**KIRKLEES METROPOLITAN COUNCIL
INVESTMENT & REGENERATION SERVICE**

DELEGATED DECISION TO DETERMINE PLANNING APPLICATIONS

Reference No: 2020/62/94299/W

Description: Formation of hardstanding for off road parking for one
vehicle including new step approach and rebuild part
of existing retaining walls (within a Conservation Area)

Job Title 16 Armitage Road , Armitage Bridge , Huddersfield , HD4 7PG			
Client Mr and Mrs M Pope			
Status Planning		Company AD	
Drawing Proposed Plan and Elevation			Scale to A1 1:50
Date Dec 2020		Drawn SB	
Drawing No. 3240 (0-) 02		Revision A

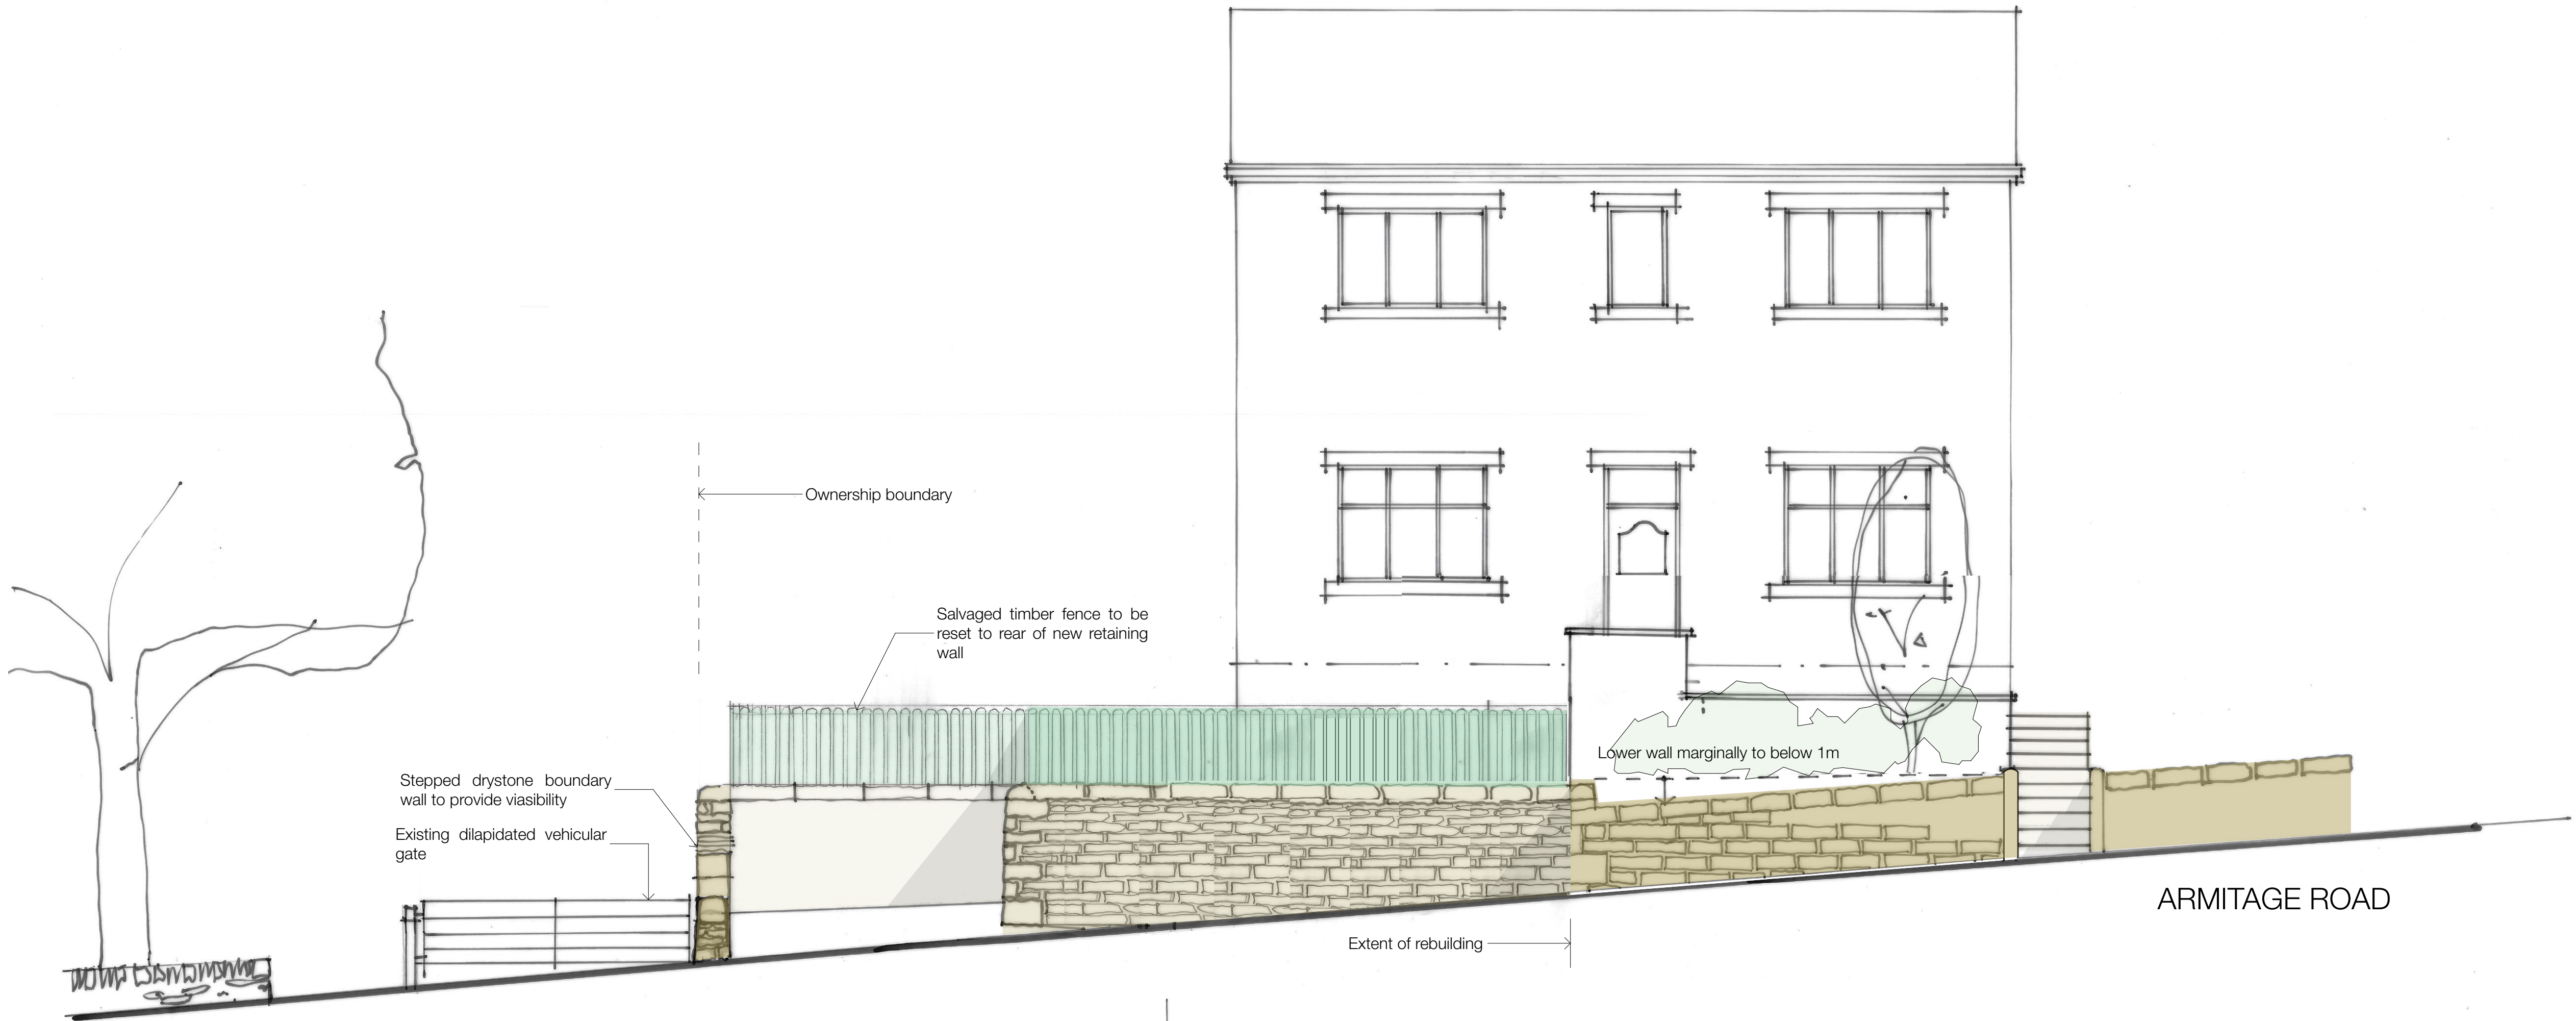
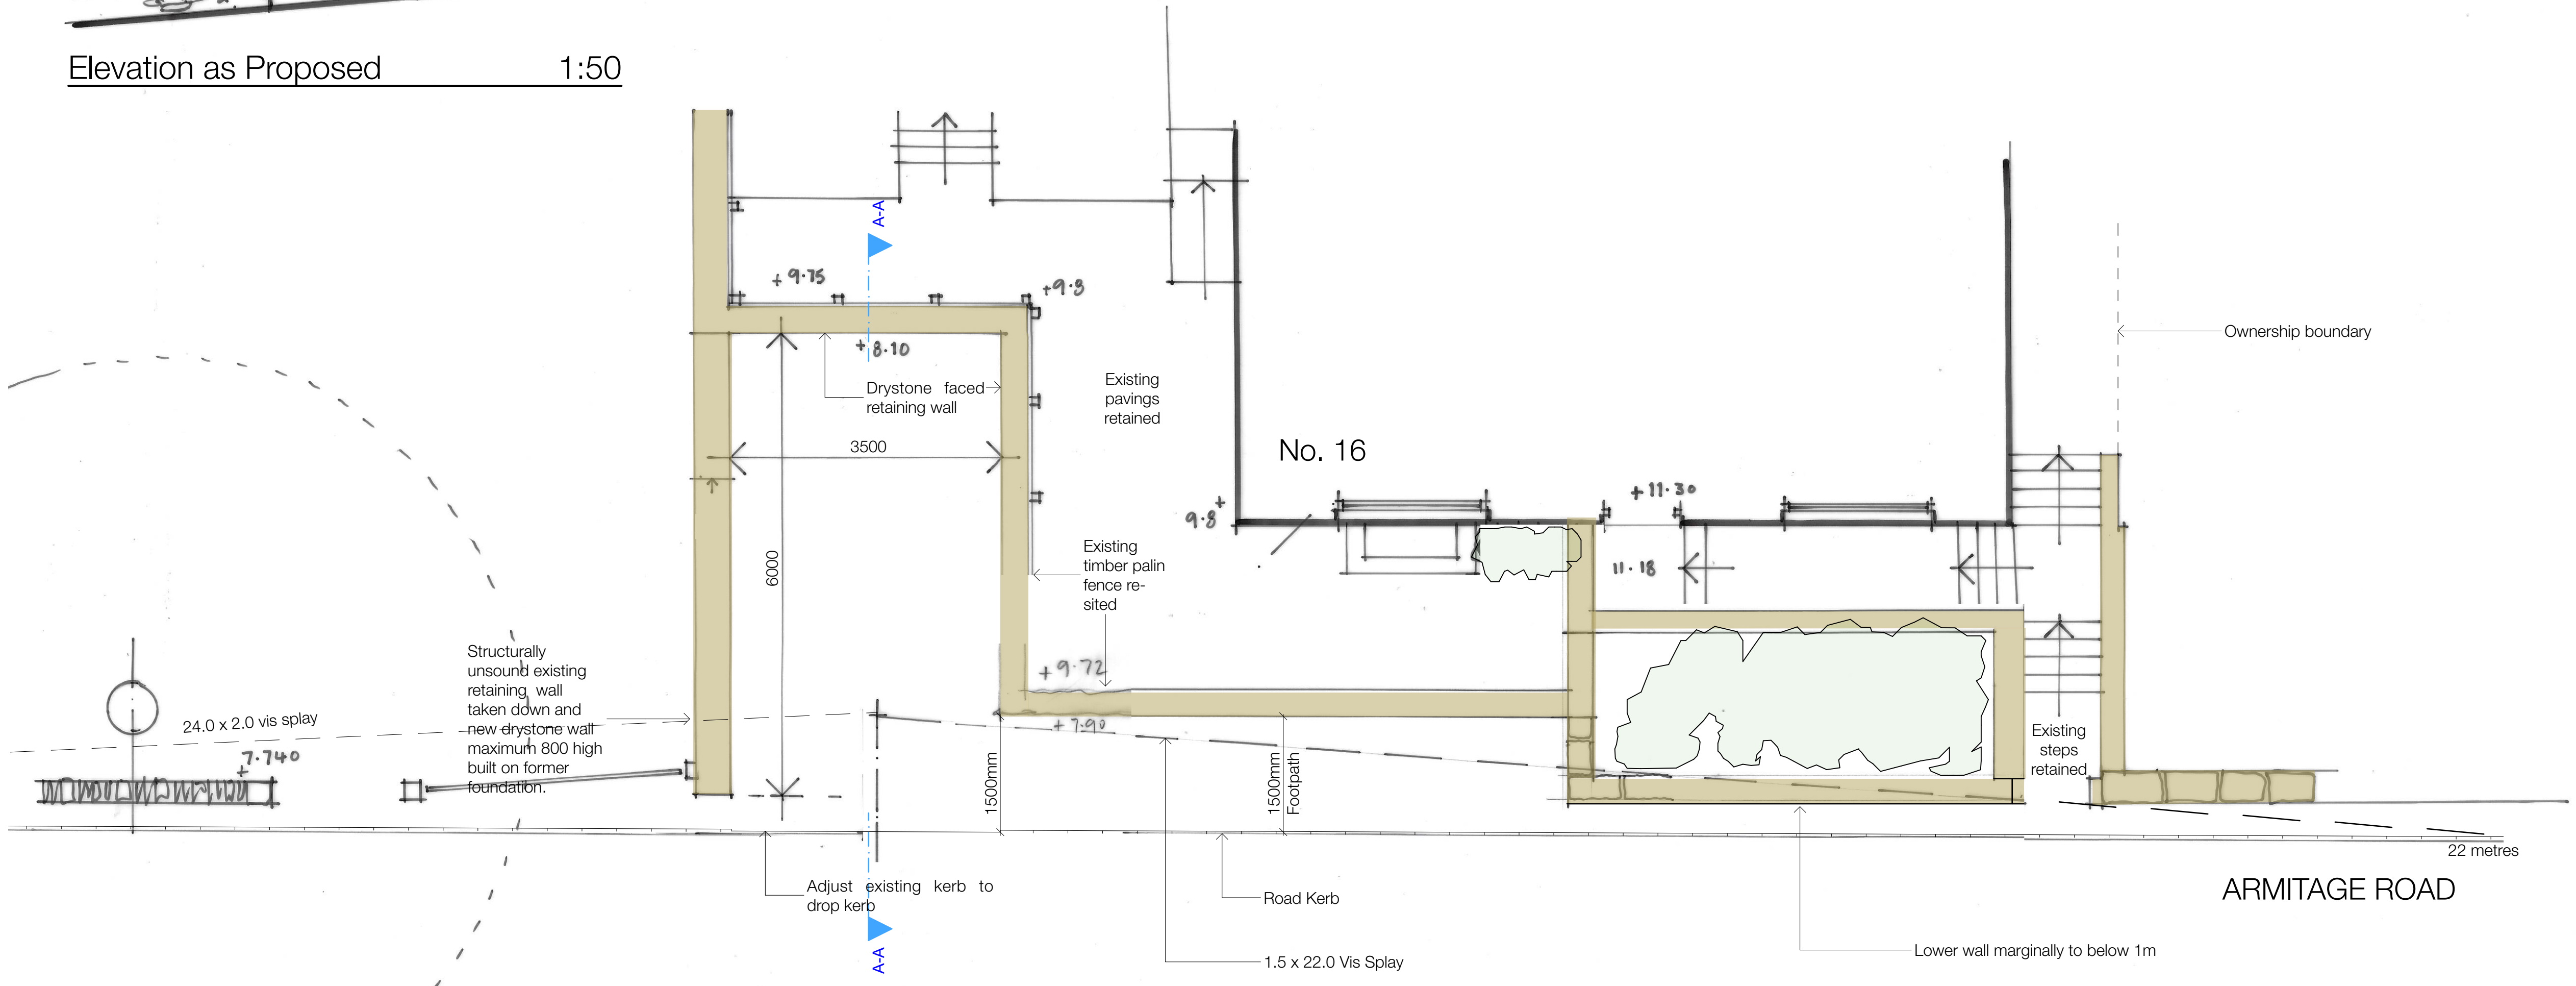
Officer note: Following amendments to the scheme requested by both Highways Development Management and the case officer based on the potential impact on the Conservation Area, the design has been amended to remove the new stairway and maintain the stone boundary wall at 1m in height. The proposals will also provide a new footpath within the site ownership for around 7 metres which will provide a refuge for pedestrians.

Officer note: Re-consultation was undertaken due to concerns over the potential impact the proposed railings would have on the character and appearance of the Conservation Area. The railings were proposed to be replaced by a stone wall similar to what exists at the site and within the streetscene. Highways then raised concerns over visibility. It was requested that visibility would need to be improved by moving or setting back the proposed steps.

Officer note: Following receipt of an amended plan which removed the proposed stairway and provides a new footpath for pedestrians, highways have stated that although the available visibility is still below the recommended for a 30mph road, it is apparent that actual driving speeds are likely to be below this given the proximity to the junction. Highways conclude that on balance, they are able to support this application.

Regarding visual amenity and the impact on the setting of the Conservation Area, whilst it is acknowledged that the proposals will alter the overall appearance of the dwelling within the streetscene it is considered that by removing the originally proposed stairway and metal railings, this has allowed the property to retain more of a traditional and sympathetic appearance, more in line with adjacent neighbouring properties. Furthermore, the proposals seek to utilise a design and materials which are reflective of what currently exists at the site, and whilst some harm to the Conservation Area is considered to arise from the proposed amendments, it is considered that the new footpath which is to be provided within the site ownership, (measuring around 7m in length), will provide a refuge area for pedestrians wanting to walk on the southern side of Armitage Road safely, and will amount to a public benefit that would, in officers opinion outweigh the harm to the Conservation Area.

The application site at present has no off-street car parking available, the proposals would provide 1 off-street car parking space by removing part of the retaining wall to the north of the site and excavating out land to create a small driveway. The driveway is to measure approximately 6m x 3.5m and is therefore considered to be of a sufficient size to allow for 1 vehicle to be parked. Part of the existing retaining wall which is to be re-built to the east will have a stepped approach to provide visibility down Armitage Road. Views to the west are to be created by stepping back the existing dry-stone wall and

timber fencing and reducing the existing wall to below 1m in height. It is also important to note that the originally proposed stairway has been removed which has allowed for better sightlines when exiting the proposed driveway. Given the above, the Council's Highways team have raised no objections to the proposals.
